Applicant: MARCIA Viles

Address: 680 Auburn St

C-B-L: 386-B-6 & 386-B-11

CHECK-LIST AGAINST ZONING ORDINANCE

PLAN OF
Boundary Survey

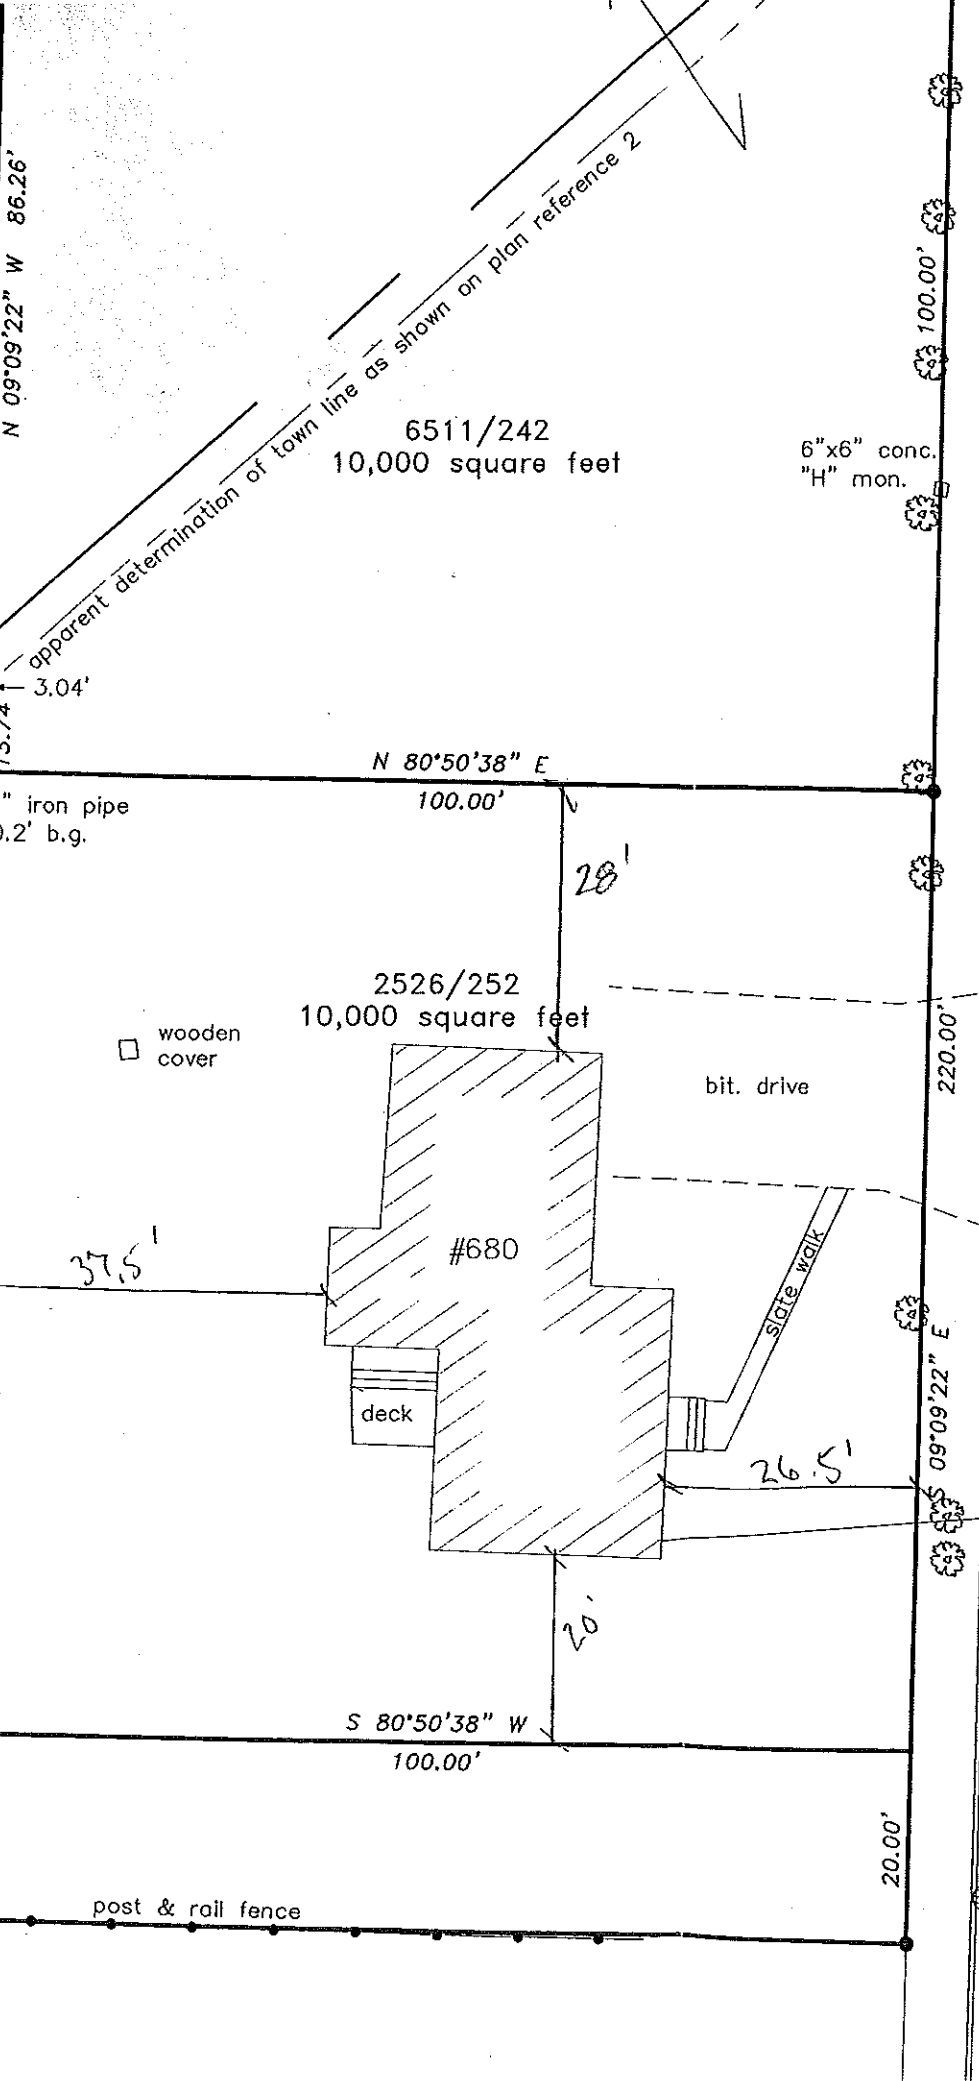
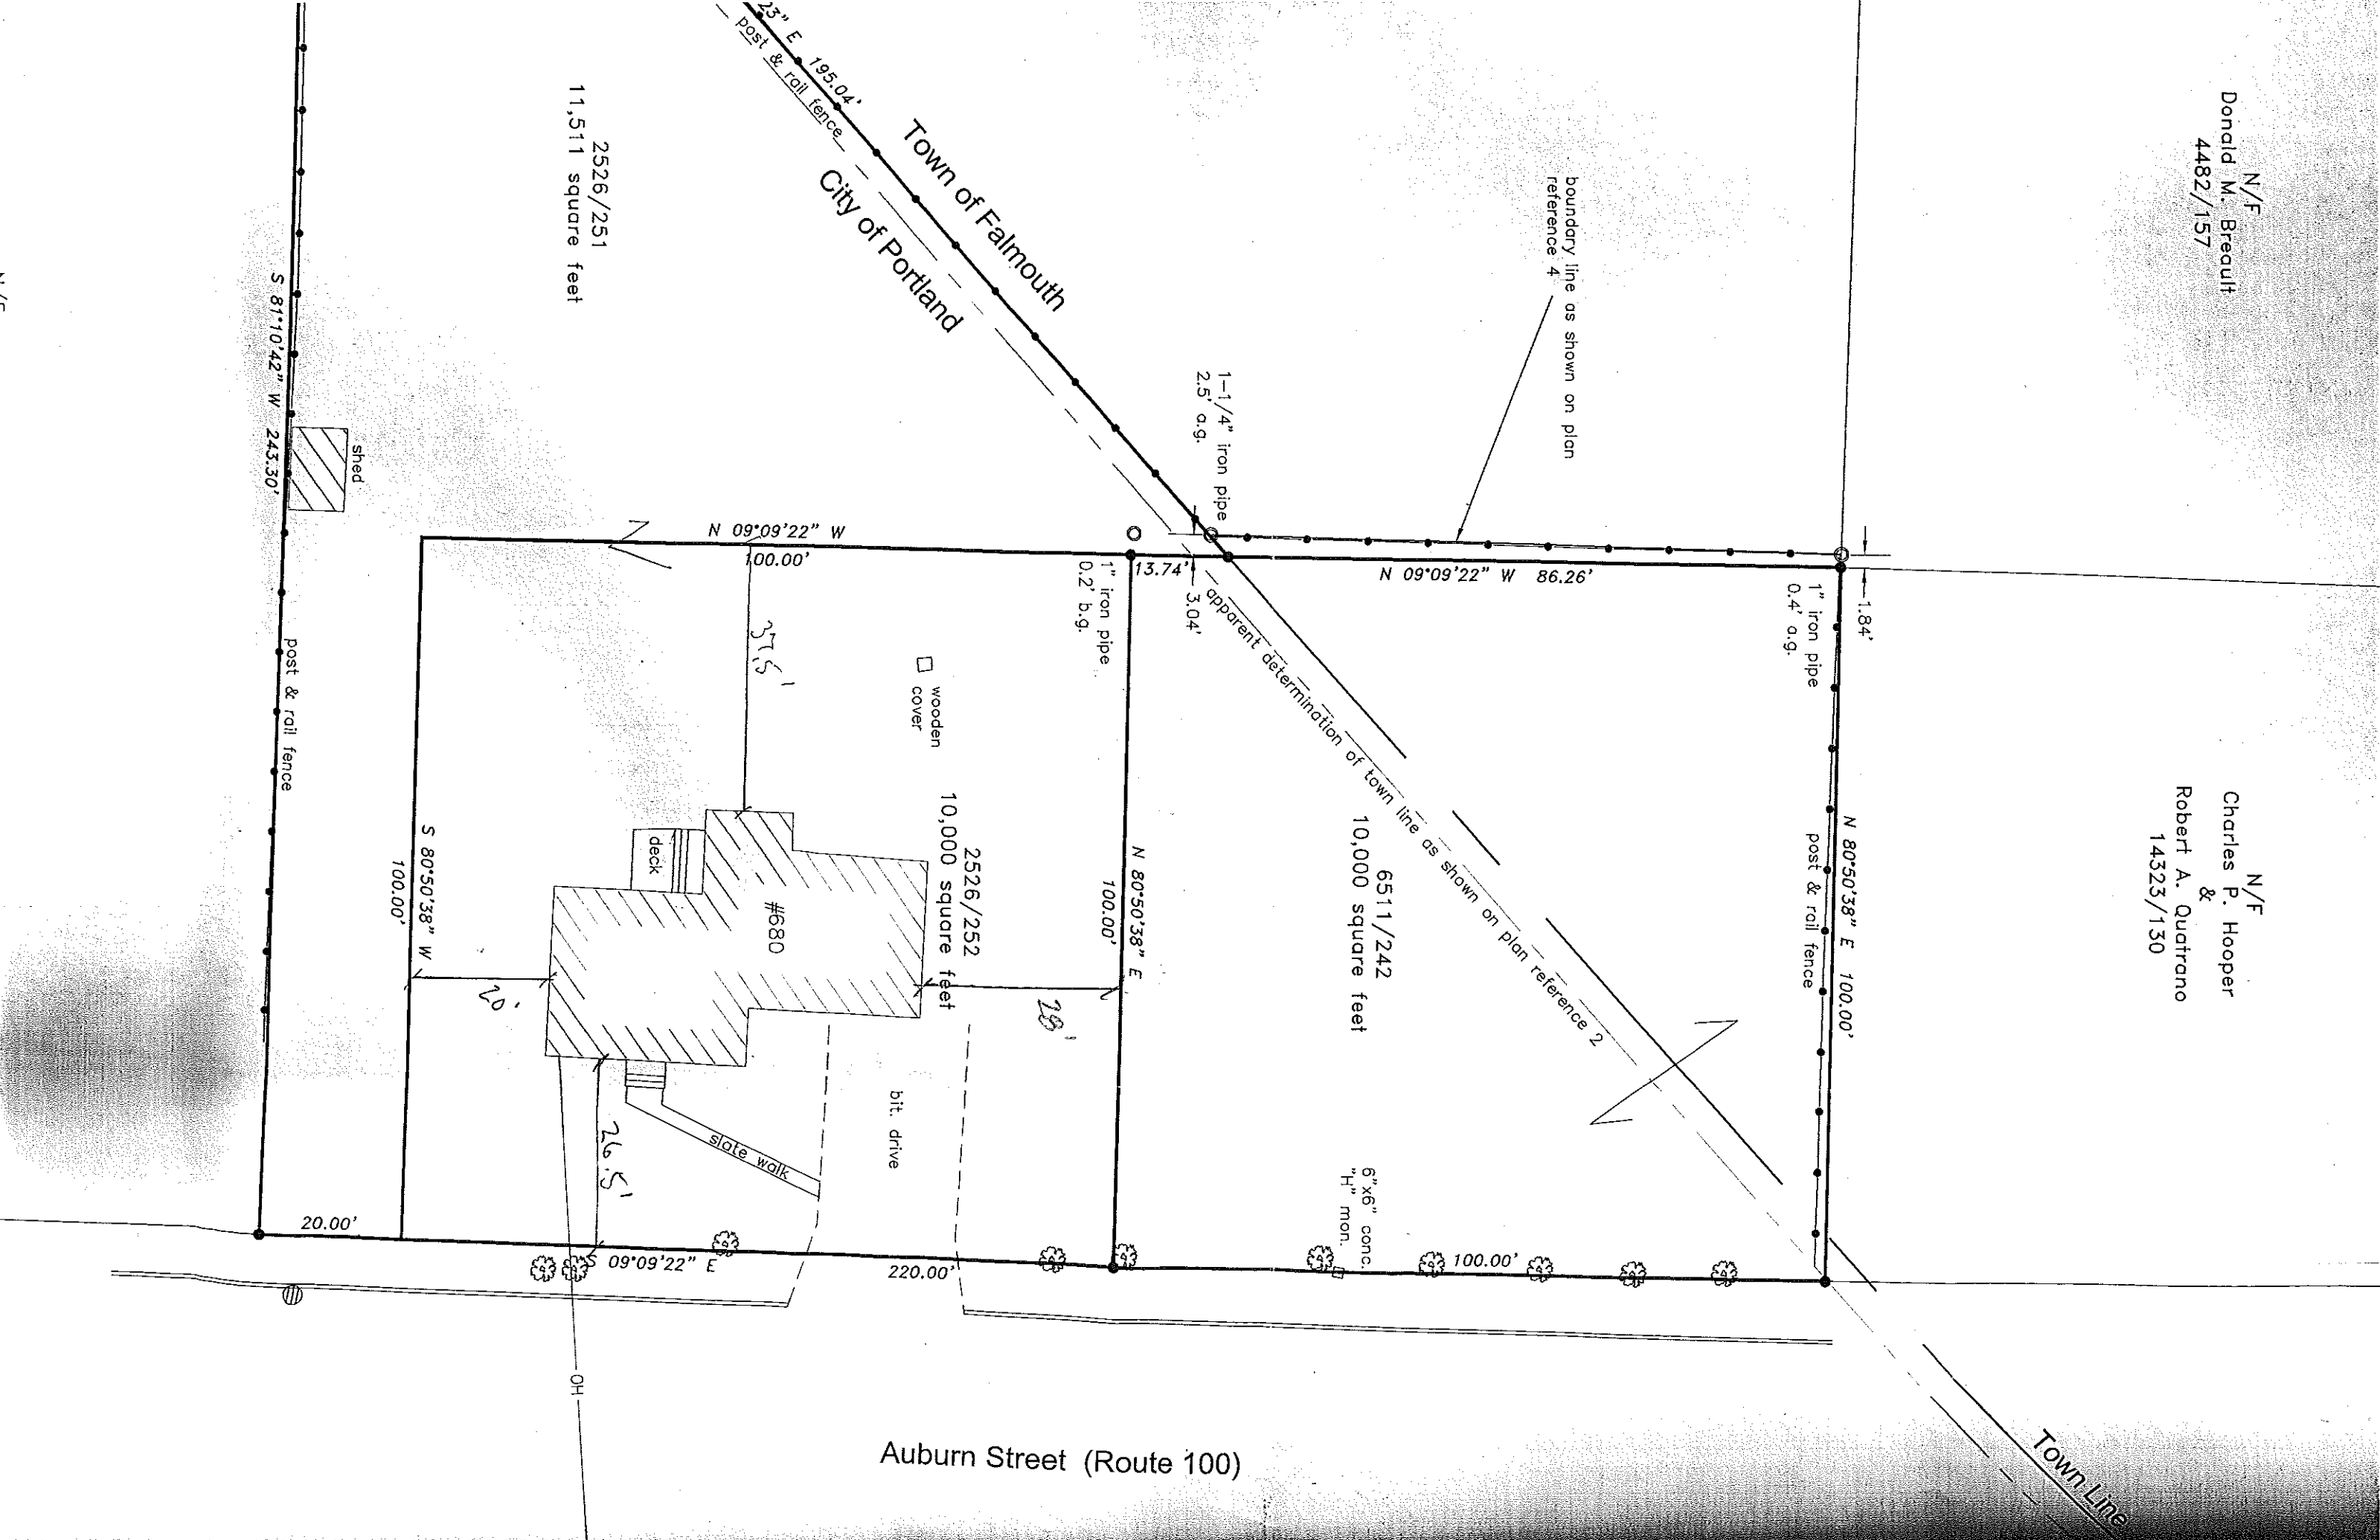
100' per Survey

100' per Survey

10,000 sq ft per Survey
(3,150 sq ft in Portland
rest in Falmouth)

10,000 sq ft
